Application for Planning Permission for Works or Extension to a Dwelling

Development: Proposed single storey front extension.
Location: 5 Church Lane Pagham PO21 4NS

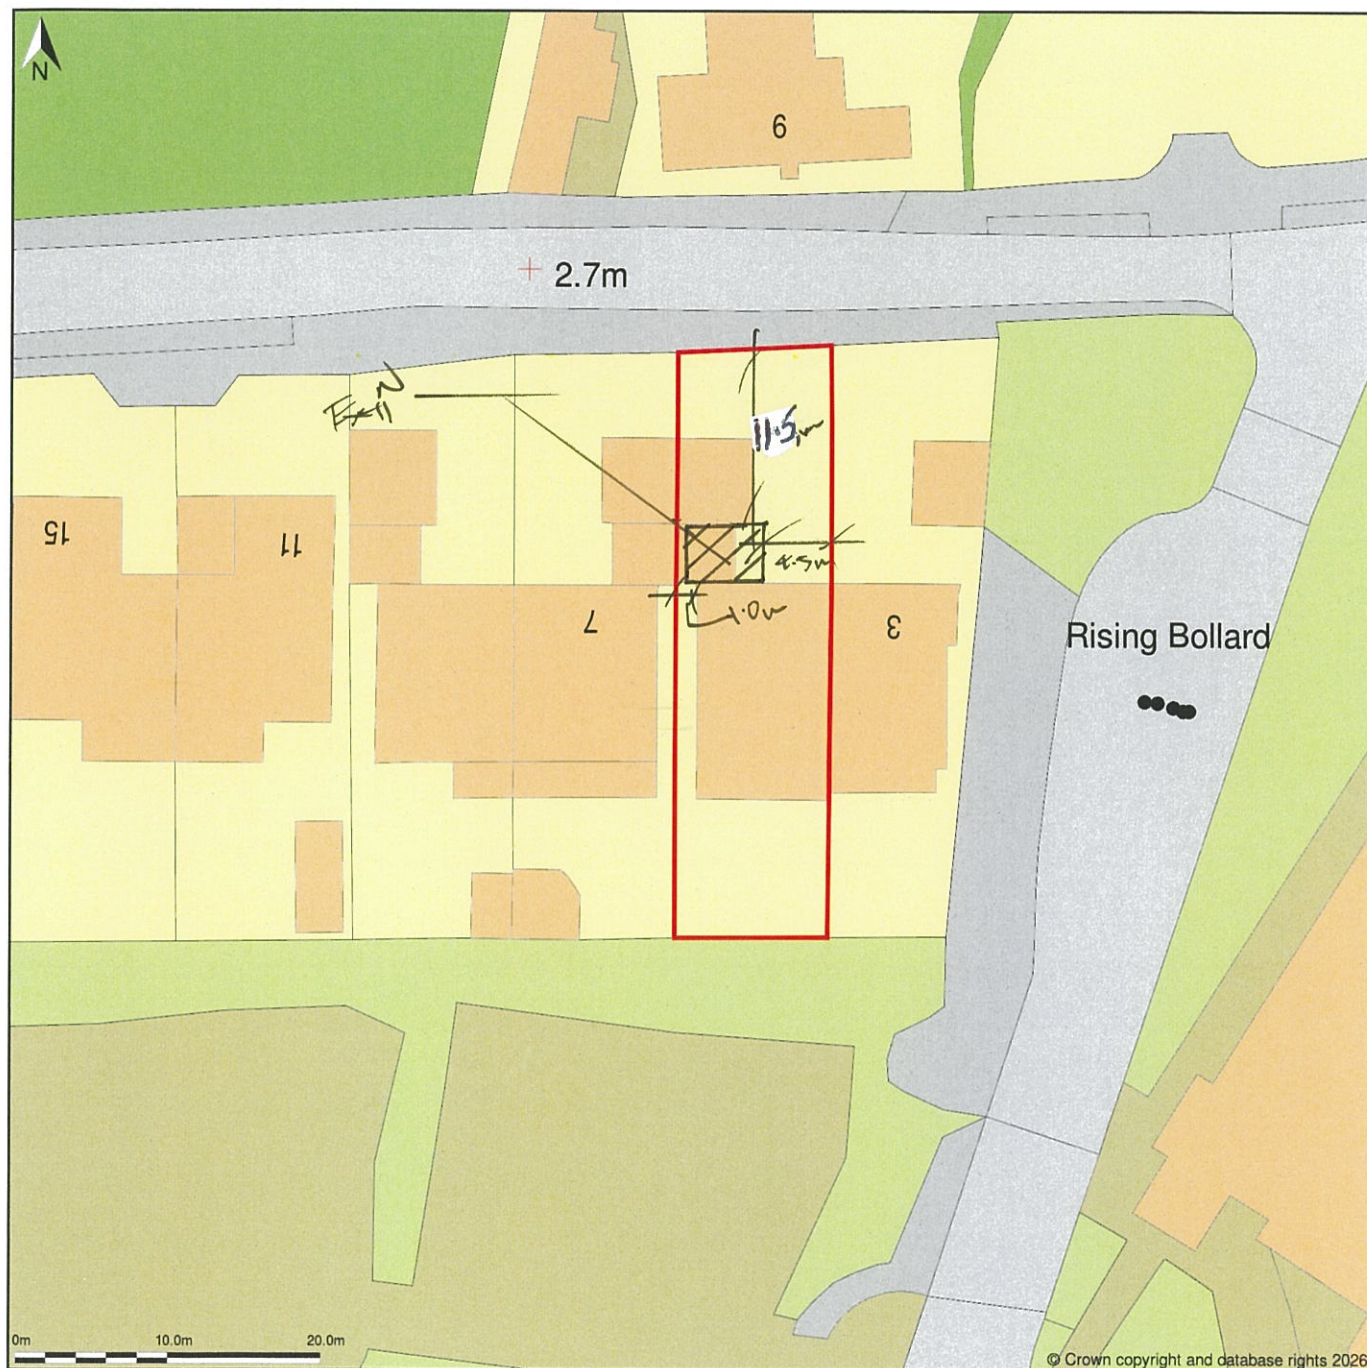
Please submit an electronic block plan with dimensions from the proposed extension to all site boundaries in pdf format at a scale of 1:500. Further details of what must be included on the plan can be found in the Validation Requirements List.

PART GROUND FLOOR
PLAN. [AS EXISTING]
1:50 @ A3.

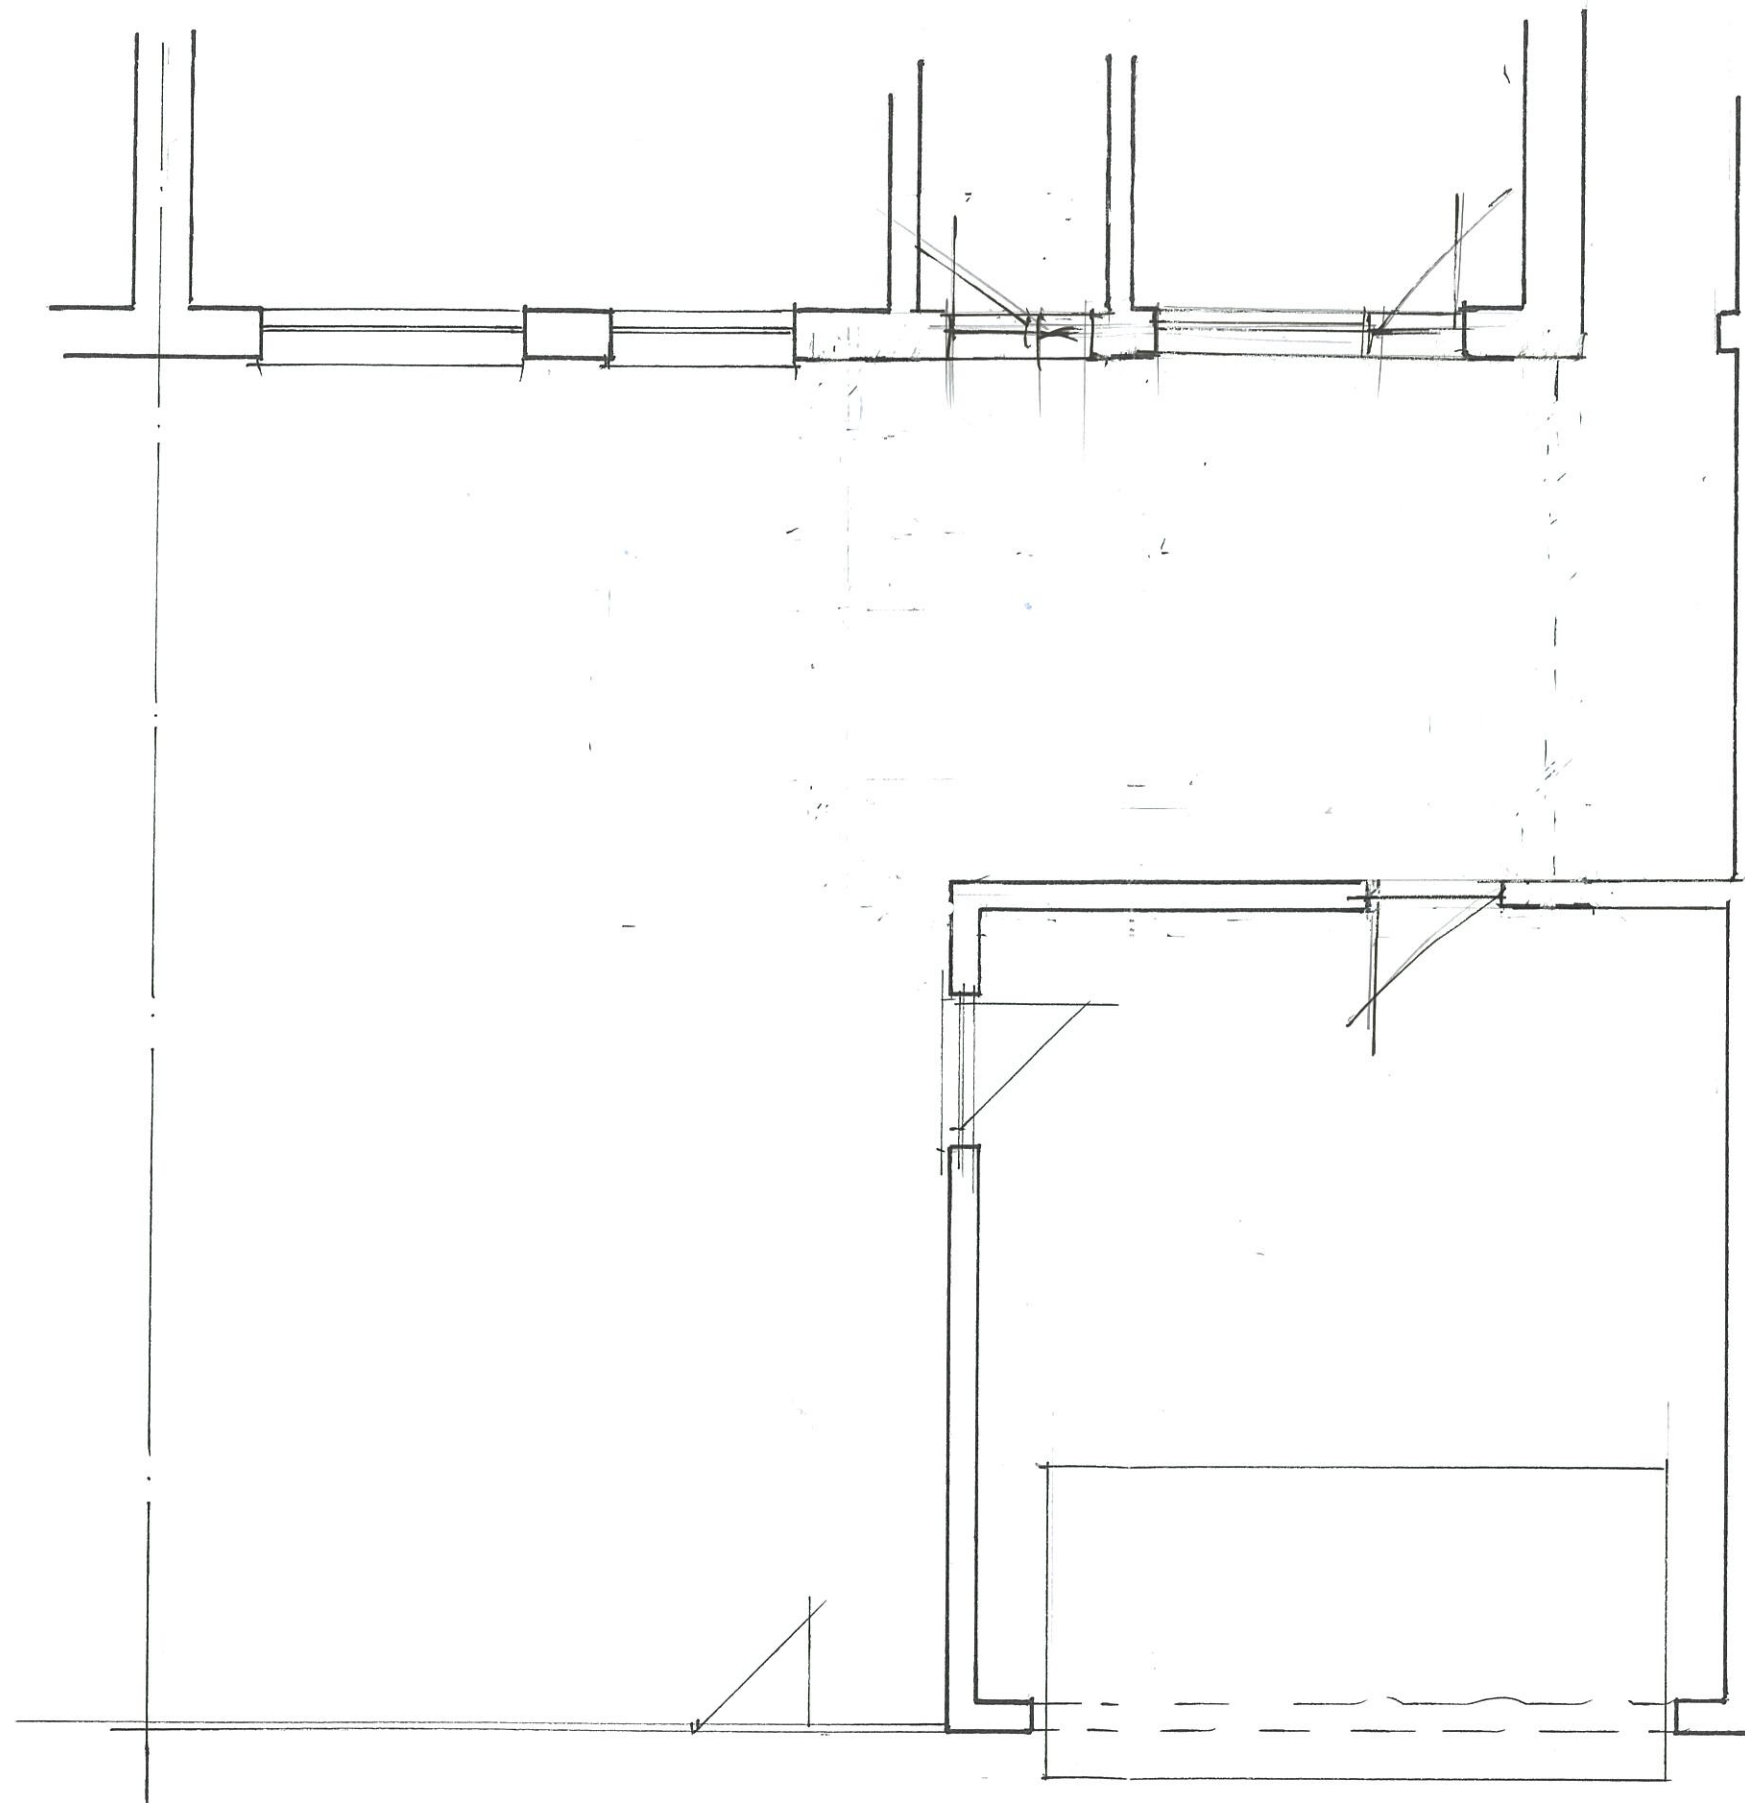
The existing floor plan has been labelled as proposed, please review and amend.
